From: Amanda Scholes on behalf of Planning.Responses
Sent: 27 June 2019 08:55
To: Planning Scanning
Subject: FW: AL/33/19/RES Barnside, Hook Lane

Please can the applicant submit a plan showing where this tank area can be provided and some proposed level demonstrating that the water can get out to the watercourse (i.e. invert level of tank, hydrobrake and ditch).

I have now had a further discussion with Laura. The reason why this is an issue for the reserved matters application is that the winter infiltration/groundwater results may conclude that infiltration is not possible. If this is the case, then the pond may need to be enlarged or space for attenuation crates provided. This could therefore affect the proposed layout.

DWG | Proposed Site Plan

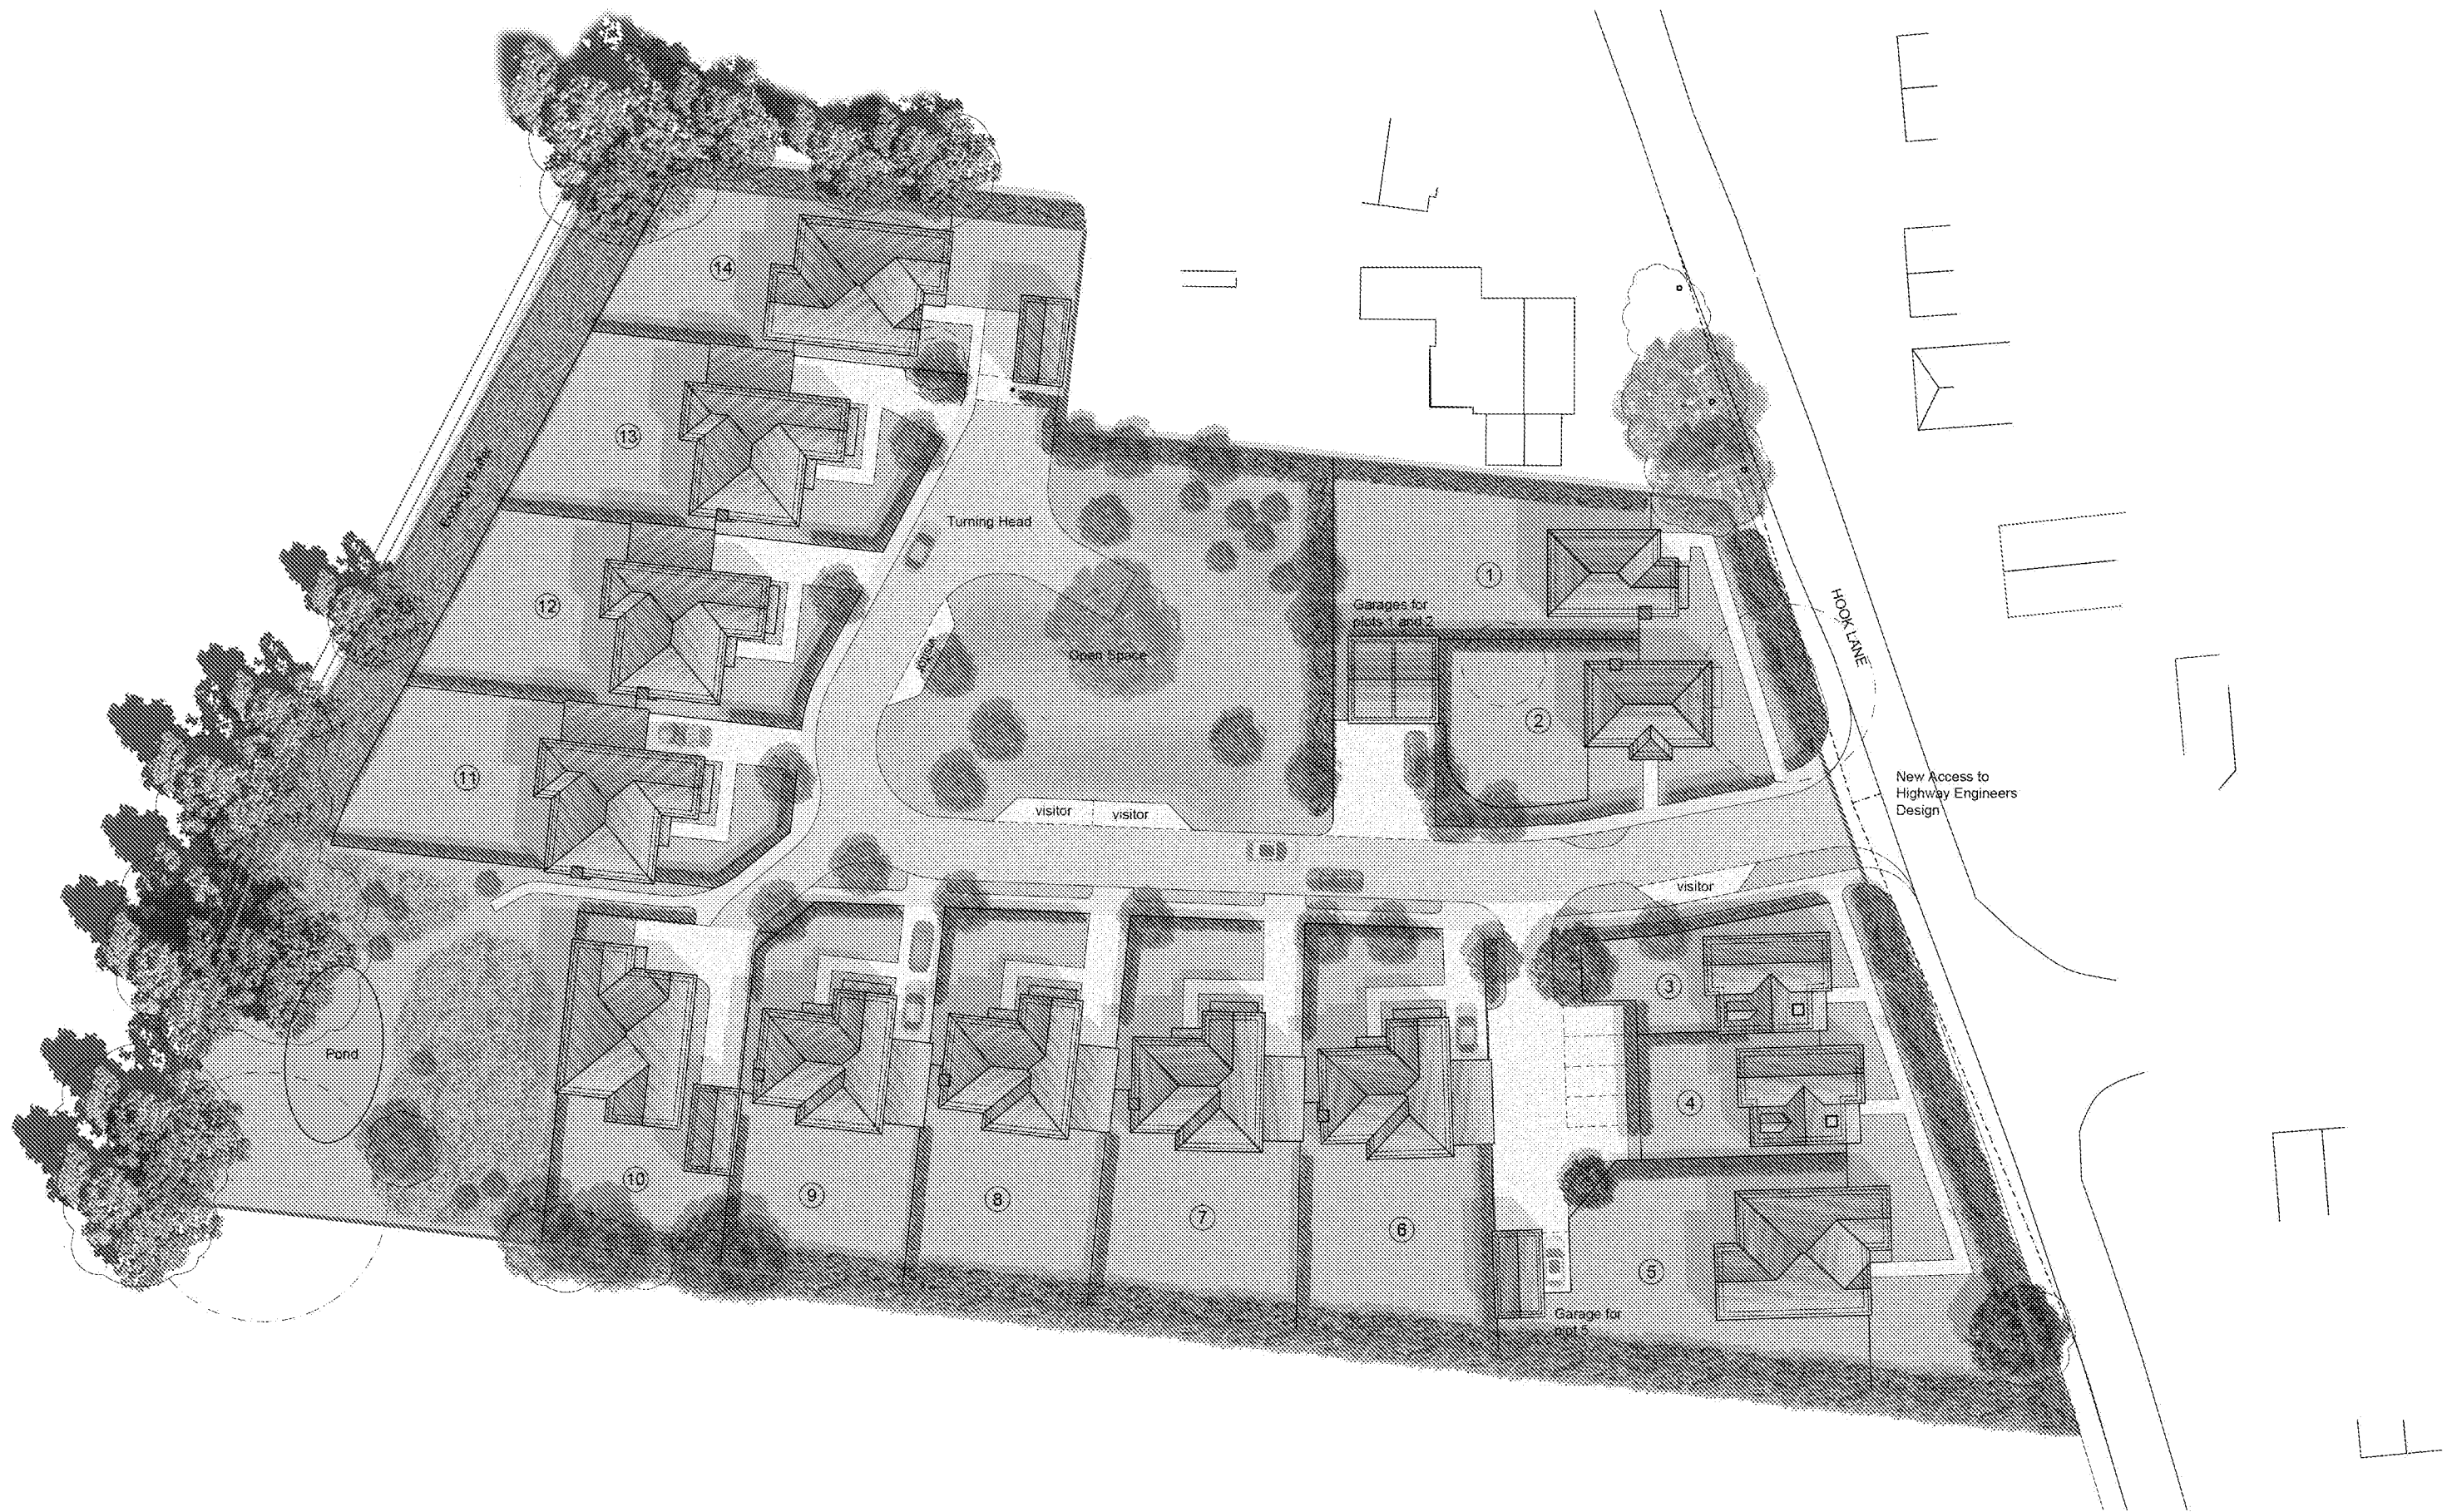
Laura has stated that she would be happy to withdraw the objection if you are able to provide a strategy type assessment which demonstrates that in a worst case scenario (no infiltration possible) that there is adequate room for surface water attenuation with the proposed layout. This could include use of the pond (above ground water level) and attenuation crates. It should be recognised within this however that regardless of such measures being provided, infiltration will be used if winter results prove it is feasible. Winter infiltration testing can then be completed to inform the approach to be taken to the DOC.

To this ends I have attached a calculation for draining the whole site to a geocellular tank located above the max GWL and buried under the central grassed area. The grassed area is 850m² so for a 0.4 height storage crate at 95% void provides 323m³ of storage. The critical event for storage is 10 hours which requires 306m³ so the available buried storage potential is more than adequate. The pond could also be enlarged as originally proposed and would provide 0.5m depth over and average footprint of 380m² above GWL ie potential for a further 190m³ Thus on site there is hypothetically potential for at least 510m³. This is greater than the runoff volume with a zero discharge rate as the design storm is only 477m³.

In summary it is certain that the proposed layout can be supported. Winter permeability tests will be undertaken in due course and maximum use made of available permeability. **If** there is any shortfall from this (up to and including 100% ie no permeability) then this will be provided as attenuation storage within the site.
